RE: Champion Home Builders #23
Lillington, NC
Model: 23-3258-02 042121

ADDITIONAL OR MODIFIED ACCEPTANCE (MODULARS/PANELIZED)

Current PFS Building System Acceptance #: 21-002679
 Model Name/ No. 23-3258-02 042121
 Manufacturer's Name: Champion Home Builders, Inc
 Plant(s) at which model will be produced Division 023, Lillington North Carolina

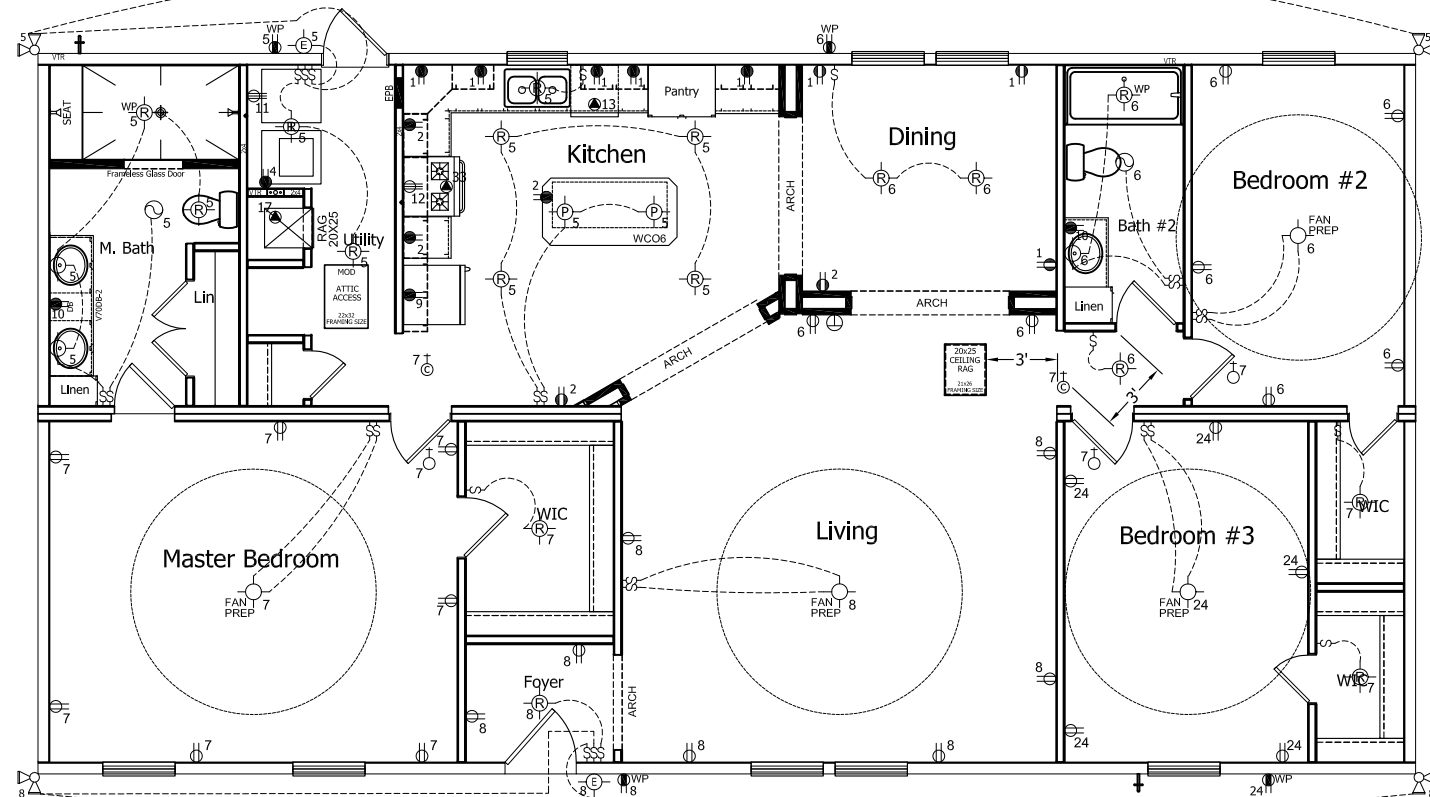
Remarks: **verify the off the kitchen smoke detector photoelectric type min 6 ft from range**
